From: Jonathan Best <Jonathan.Best@arun.gov.uk>
Sent: Monday, March 25, 2024 3:58 PM
To: Planning.Responses <Planning.Responses@arun.gov.uk>
Cc: Jessica Riches <Jessica.Riches@arun.gov.uk>; David Easton <David.Easton@arun.gov.uk>
Subject: AL/11/24/OUT

I have reviewed this application with regards to ecology.
My comments are provided below.

AL/11/24/OUT
Land East of Westergate. Westergate

Hybrid application consisting of: 1) Outline permission for all matters reserved (except access) for up to 400 No dwellings and associated works and 2) Full planning permission for alterations to site access off Westergate Street and through Pine Close and east-west link road including a bridge over the Lidsey Rife. This application also lies within the parish of Barnham, falls within Strategic Site SD5, CIL Zone 1 (Zero Rated), affects the setting of listed buildings, affects the character and appearance of the Eastergate Church Lane Conservation Area, affects public rights of way. This application is the subject of an Environmental Statement.

Figure 18. Key bat commuting routes identified across the site. Red circle==location of Barbastelle bats, blue circle= confirmed location of Bechstein's Bat.

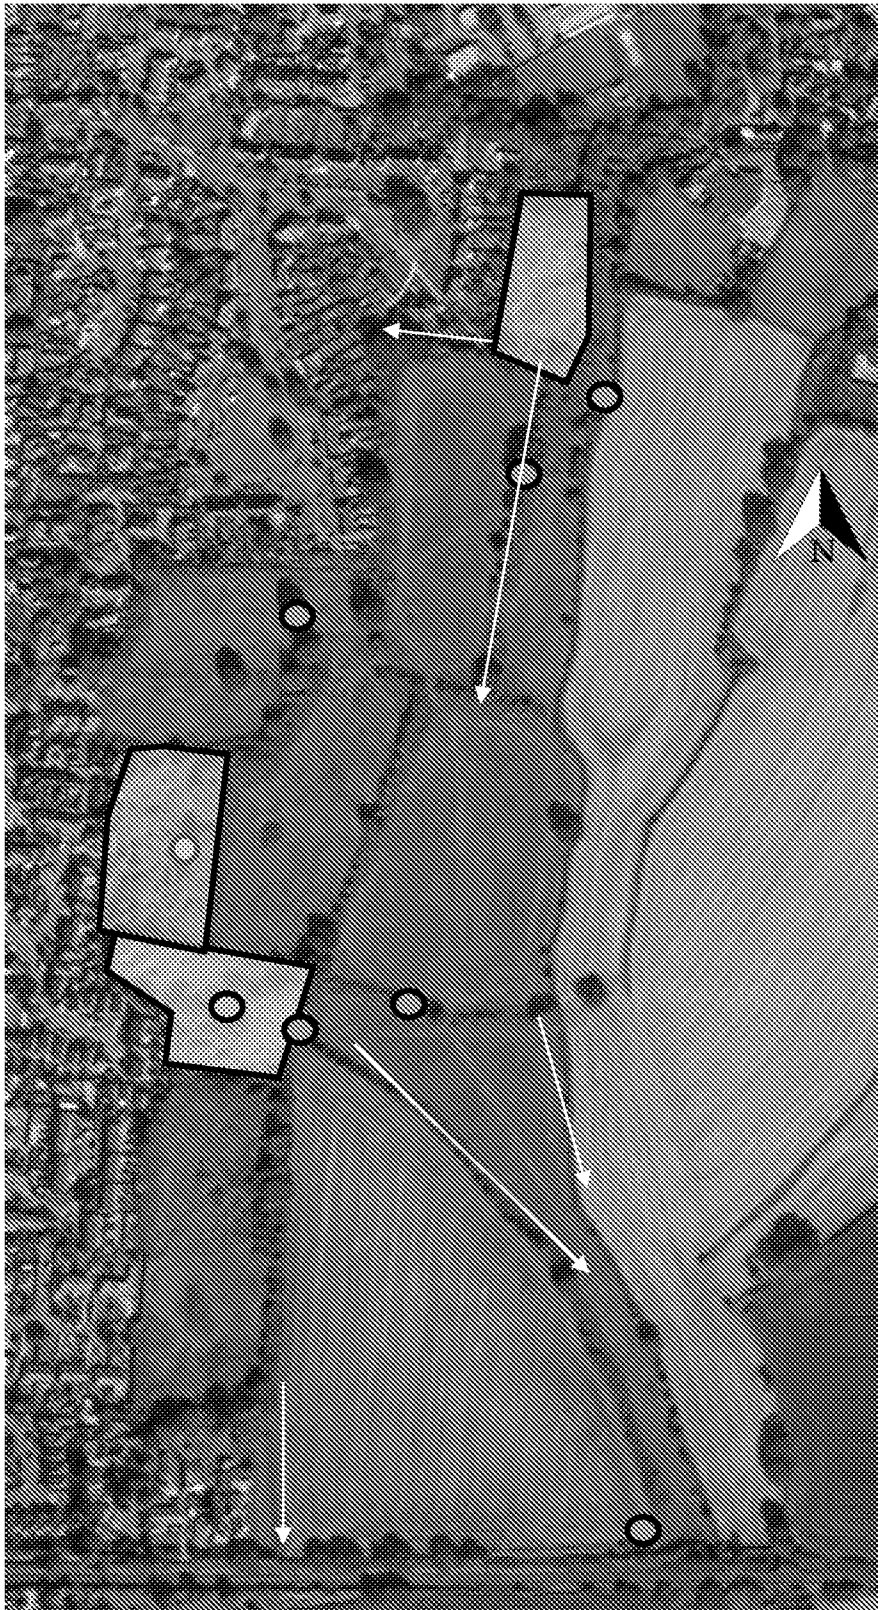
The EIA assessment of bat commuting and foraging is set out below.

Bechstein was recorded in the wet woodland. Rare barbastelle and plecotus species recorded across the site. Both are light sensitive and will likely be disturbed during and after the development.

Light, when the development is operational lighting will be introduced on site via the use of both street lamps and security lighting associated with the properties themselves. As currently there is a limited amount of existing lighting in place this will have **certain major negative impacts** upon nocturnal species such as bats (notably commuting Barbastelles which are of regional ecological value) and Badgers.

The lighting must comply with the BCT guidance. There are rare bats foraging and commuting within the site. Dark corridors proposals are included in the EIA 8.1.5.1 *Dark Corridors*. These proposals are acceptable.
